Our ref: OUT24/7486

Subject: The Plains Wind Farm (SSD-50629707) – Environmental Impact Statement

Detailed advice to DPE Planning & Assessment regarding The Plains Wind Farm (SSD-50629707) – Environmental Impact Statement

Figure 1: Project Layout

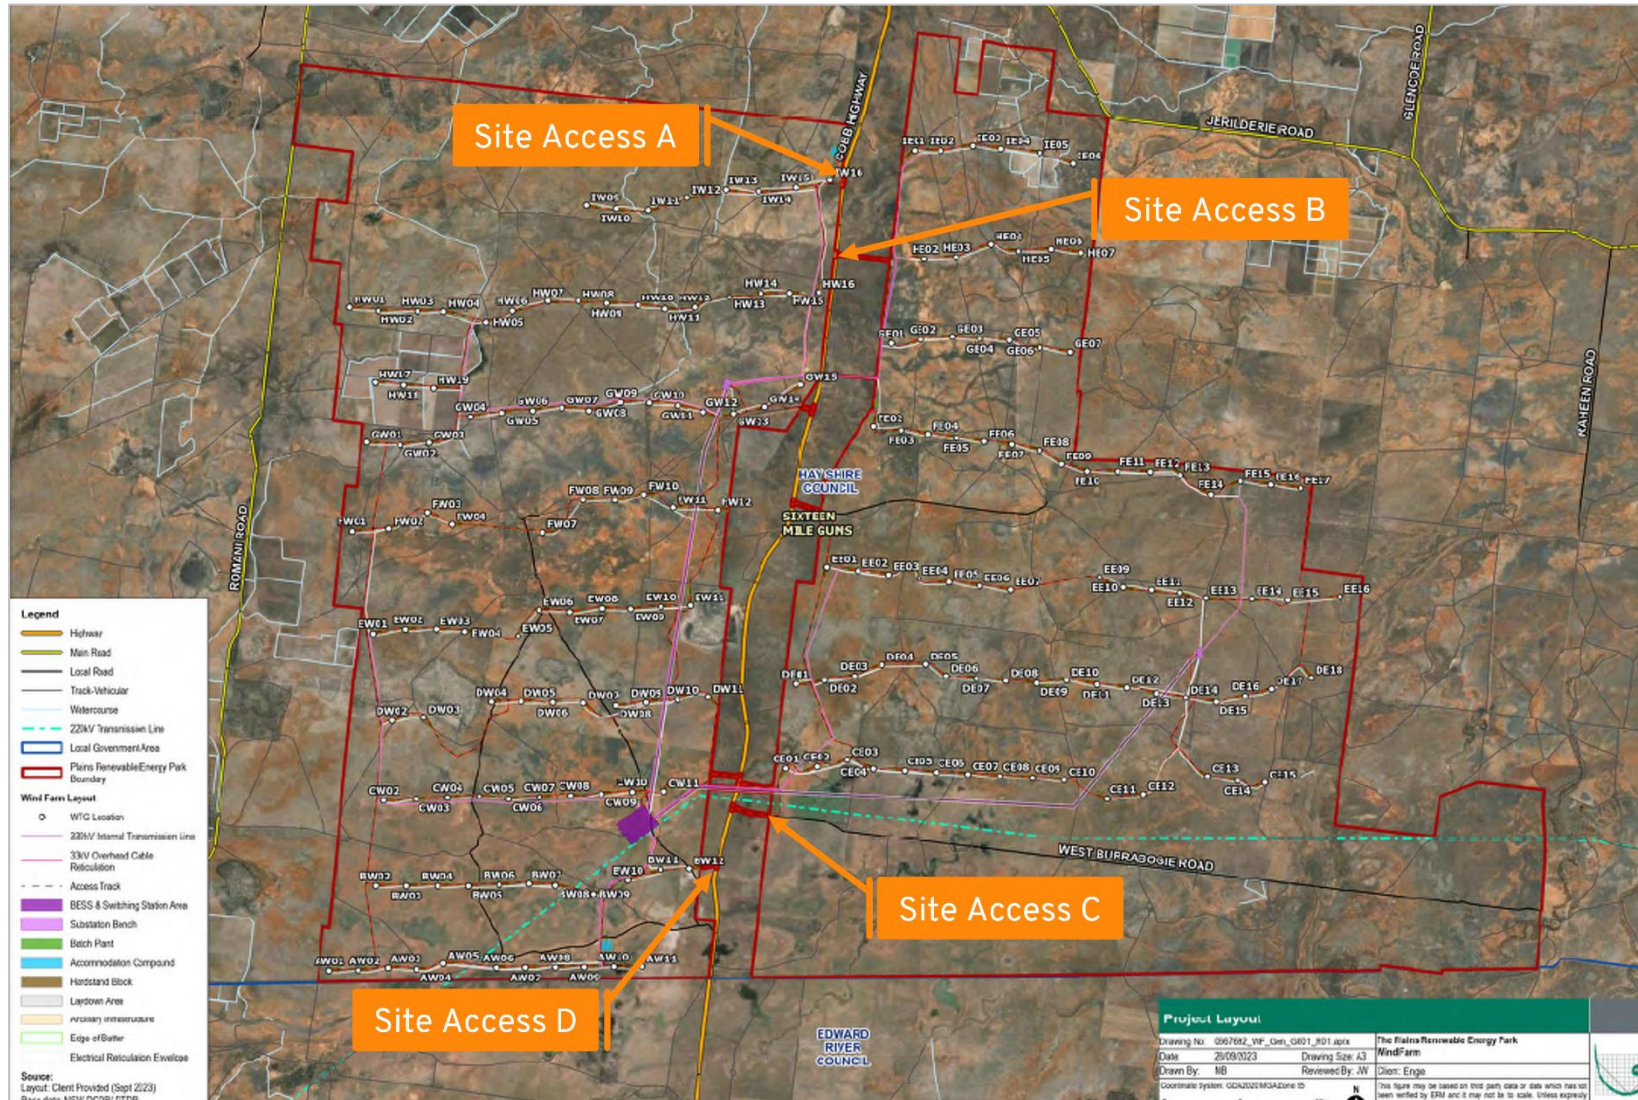
The proponent should provide clarification of the proposed infrastructure layout to meet the buffer requirements from watercourses as defined in the Guidelines for Controlled Activities on Waterfront Land (DPE 2022).

It is unclear if the proposed turbines will be outside setback limits from waterfront land. Setbacks should be in accordance with the Guidelines for Controlled Activities, and the layout should be amended if required to meet these limits. It is unclear if the location of underground cables impact waterfront land and the construction and design of stream crossings need to consider stream order in accordance with the Guidelines for Controlled Activities.
